Submission Opposing Project Mars Data Centre Development

Application Reference: SSD-82052708

Submitted by: Resident of Wood Street, Lane Cove West NSW 2066

2 20TH SEPTEMBER - 12PM - PROPOSED
 1 : 2000

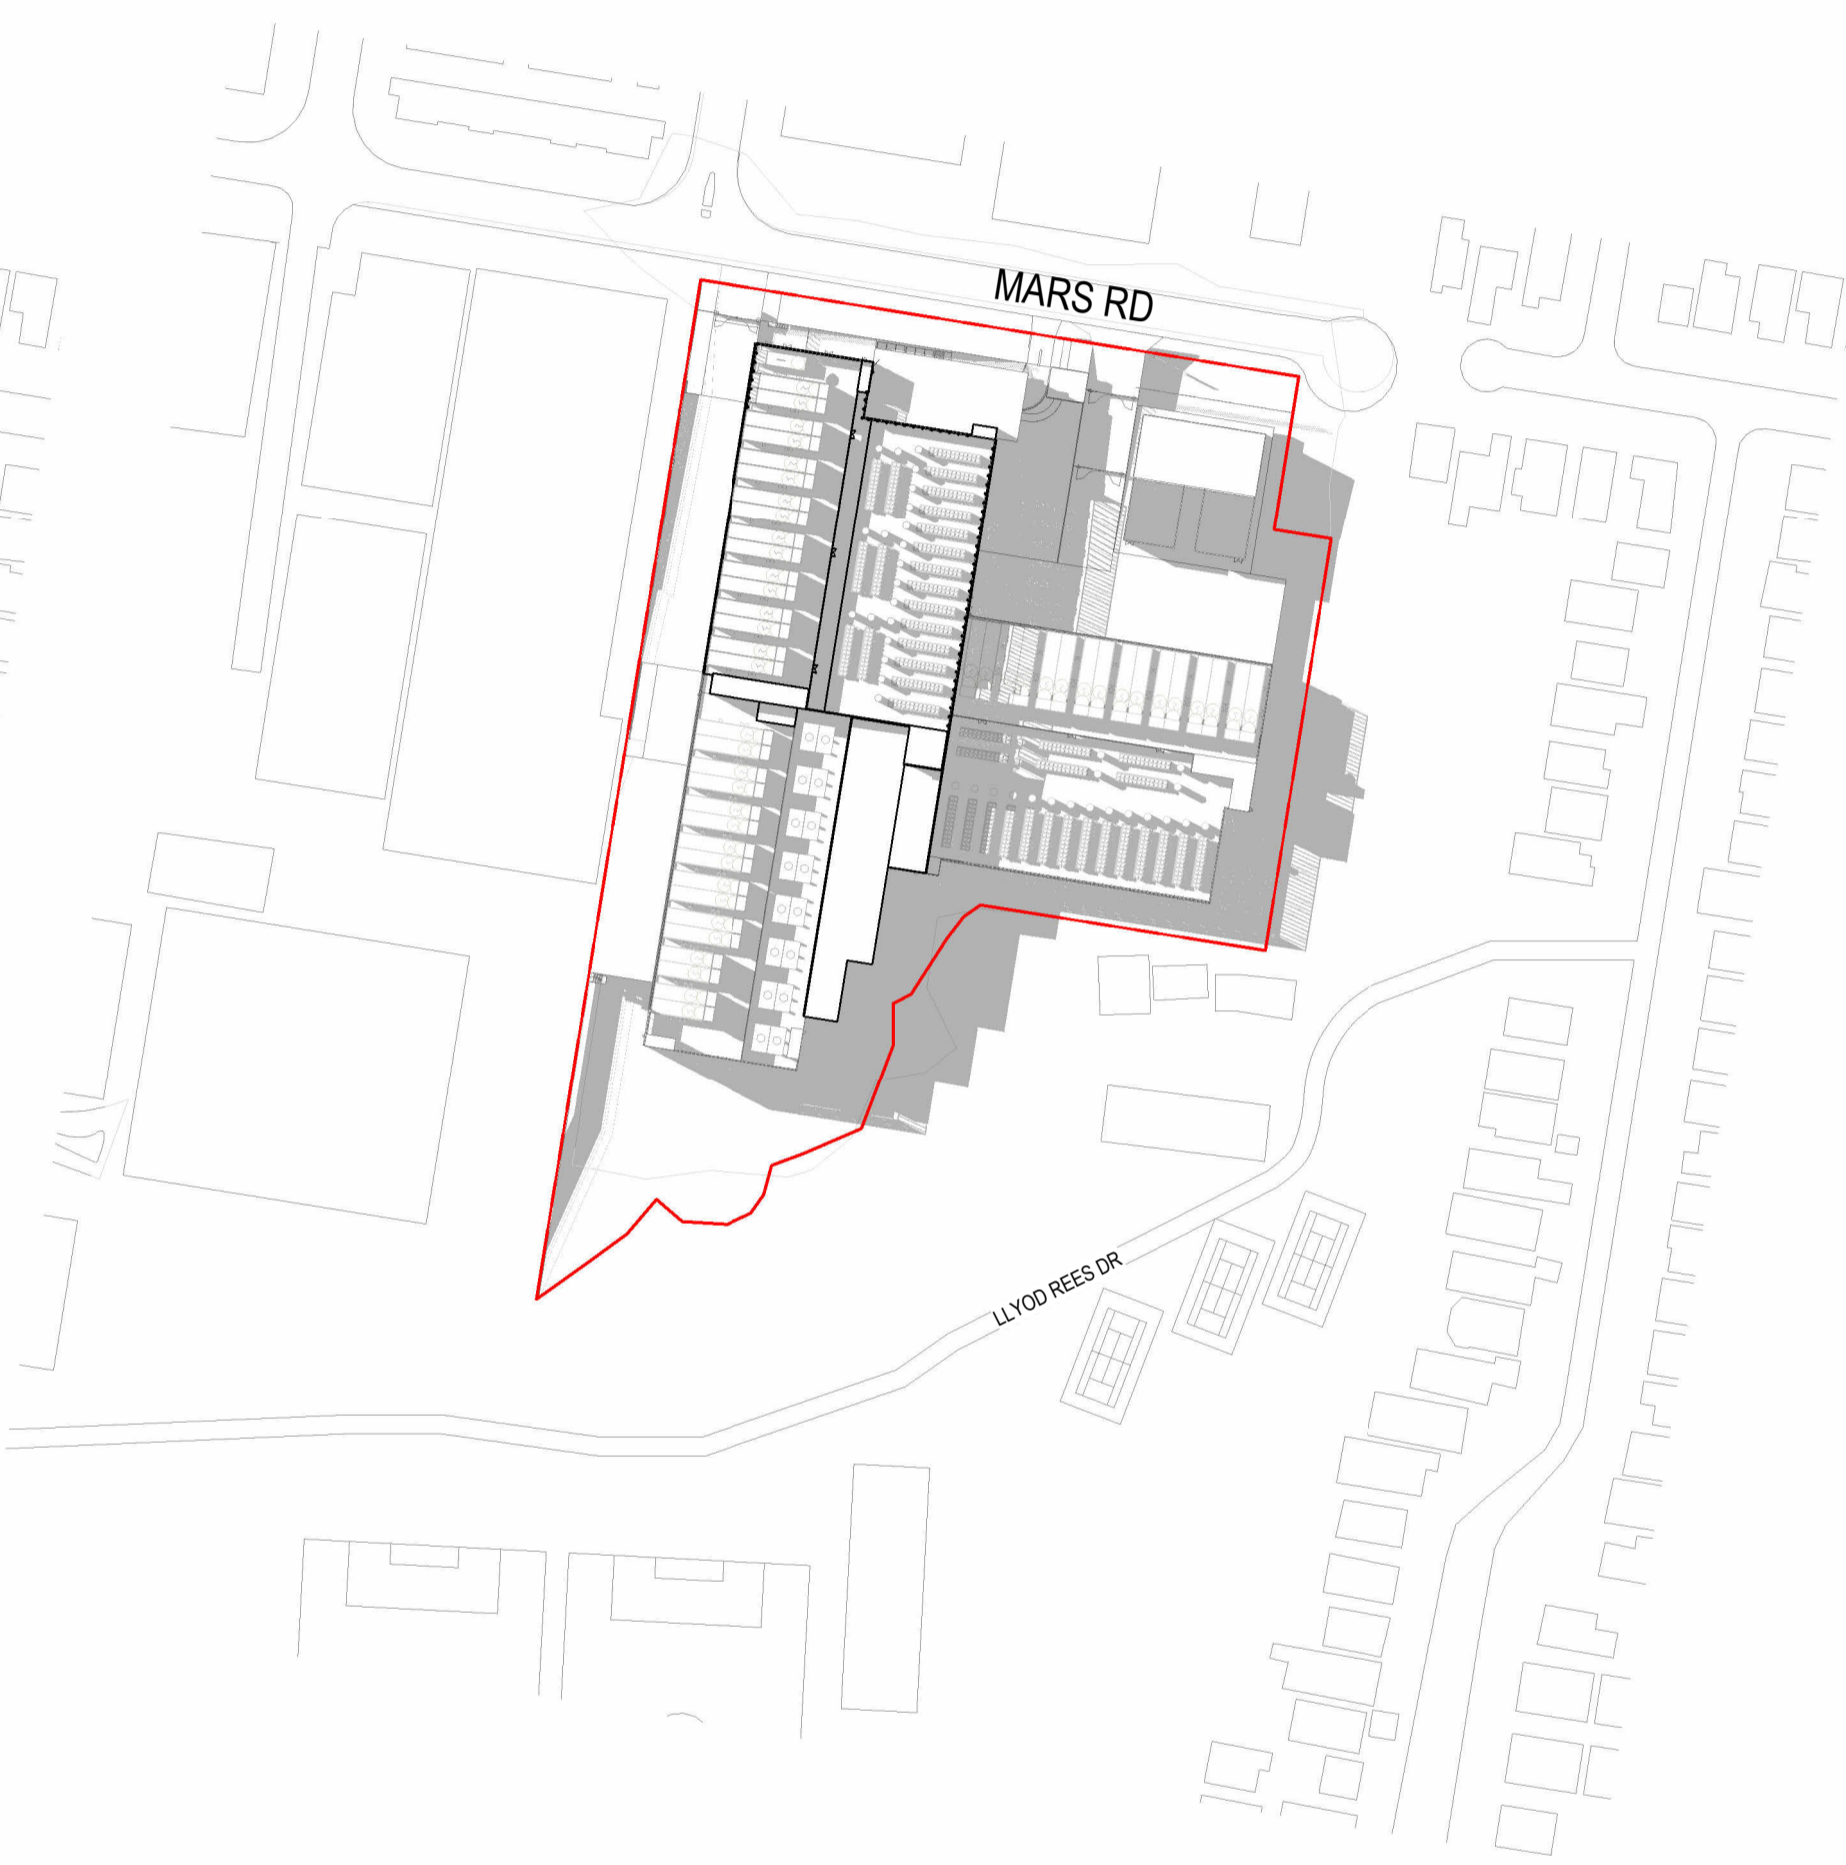
The EIS visual impact assessment uses a limited selection of viewpoints and computer-generated imagery. There are no detailed overshadowing diagrams

demonstrating impacts on Blackman Park across different seasons and times of day. There is no analysis of the loss of residential privacy for homes on Wood Street and surrounding streets, or of the loss of solar access to neighbouring properties and the park.

1 EAST ELEVATION
1 : 500

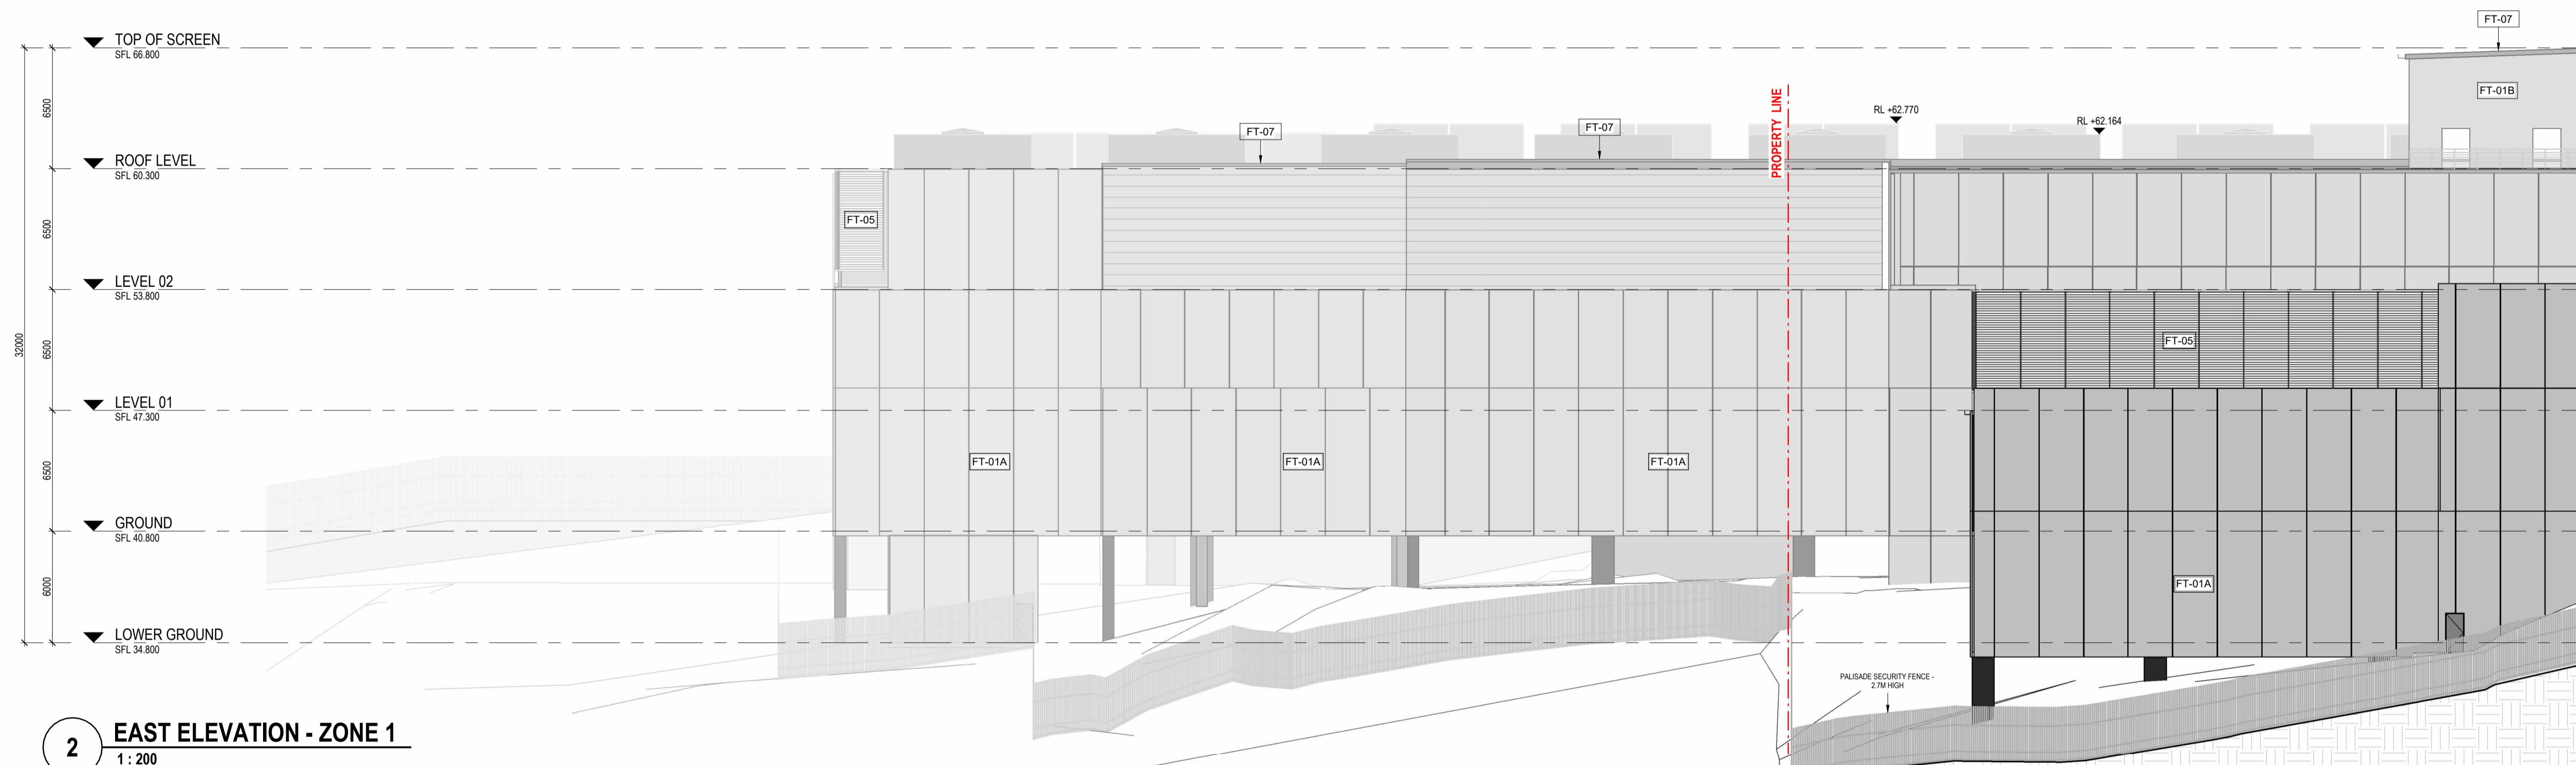
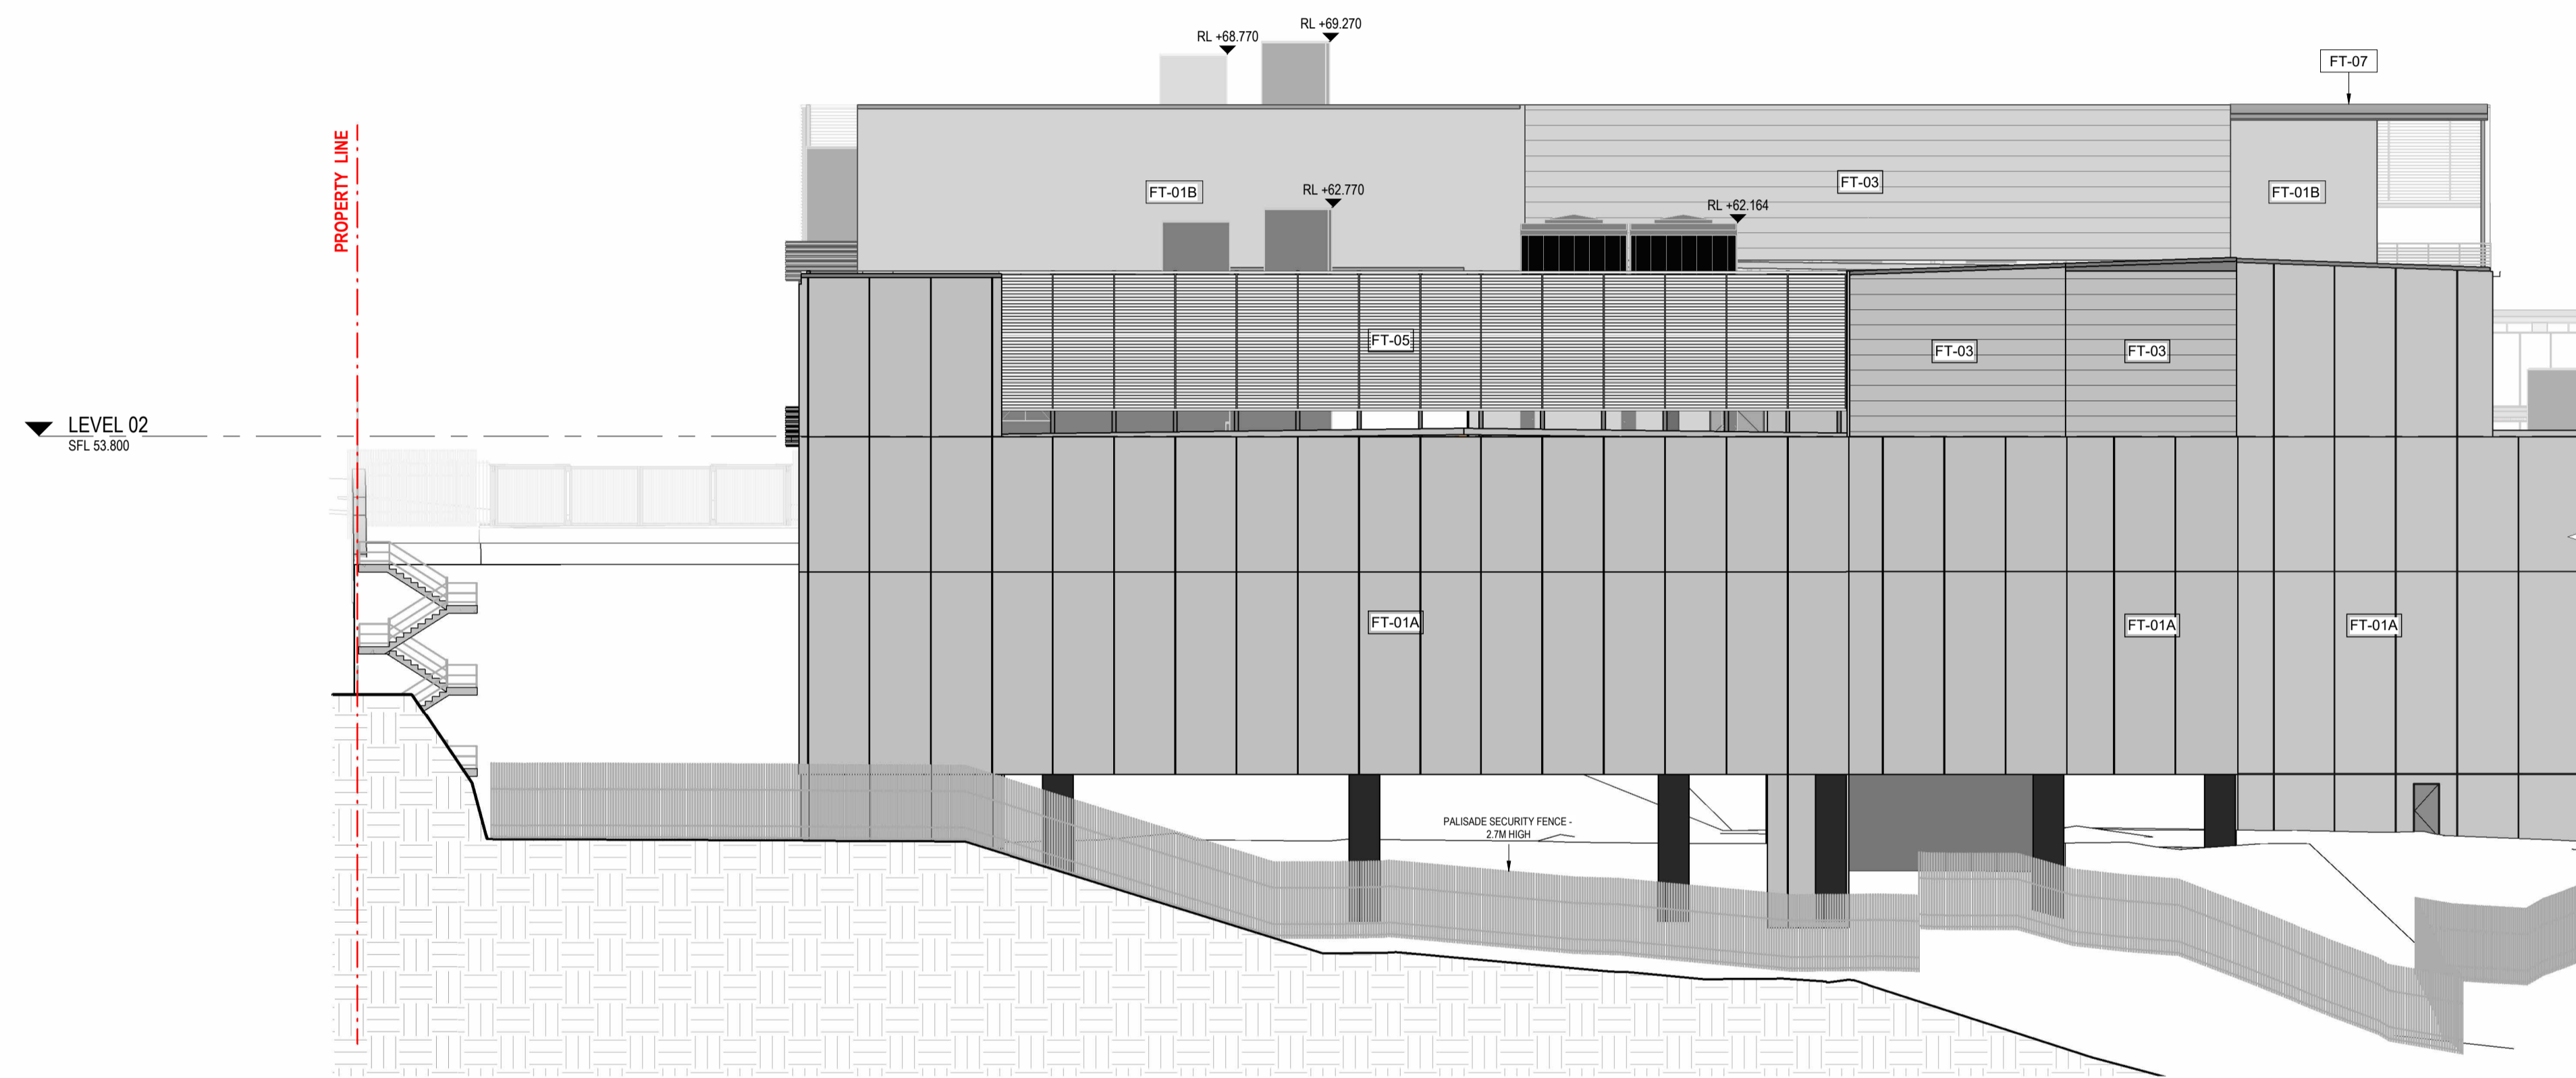
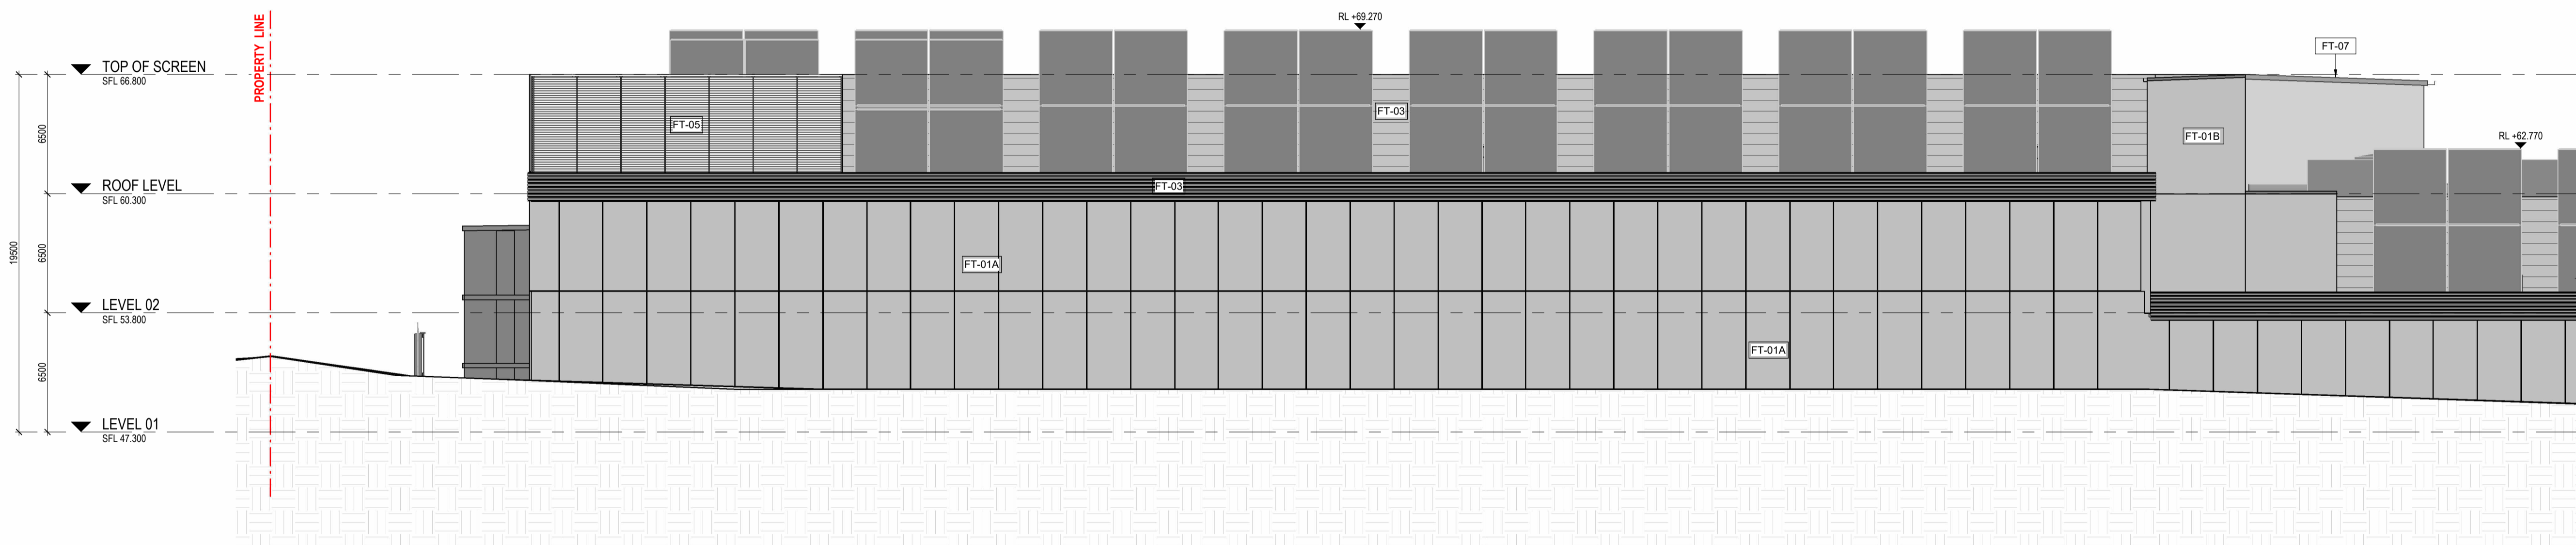
The proposed building will be between 15 and 25 metres tall. This exceeds the applicable height standard under the Lane Cove Local Environmental Plan (LCLEP), requiring a Clause 4.6 variation. Lane Cove Council has explicitly flagged that the structure's height "far exceeds local restrictions." I object to the grant of this variation.

The site is elevated above Blackman Park — public recreation land zoned RE1 to the south — and the eastern boundary has only a 50 metre landscape setback before transitioning to R2 Low Density Residential land. A 25-metre structure with only a 50-metre setback to residential land and overlooking a public park is not appropriate in this location.
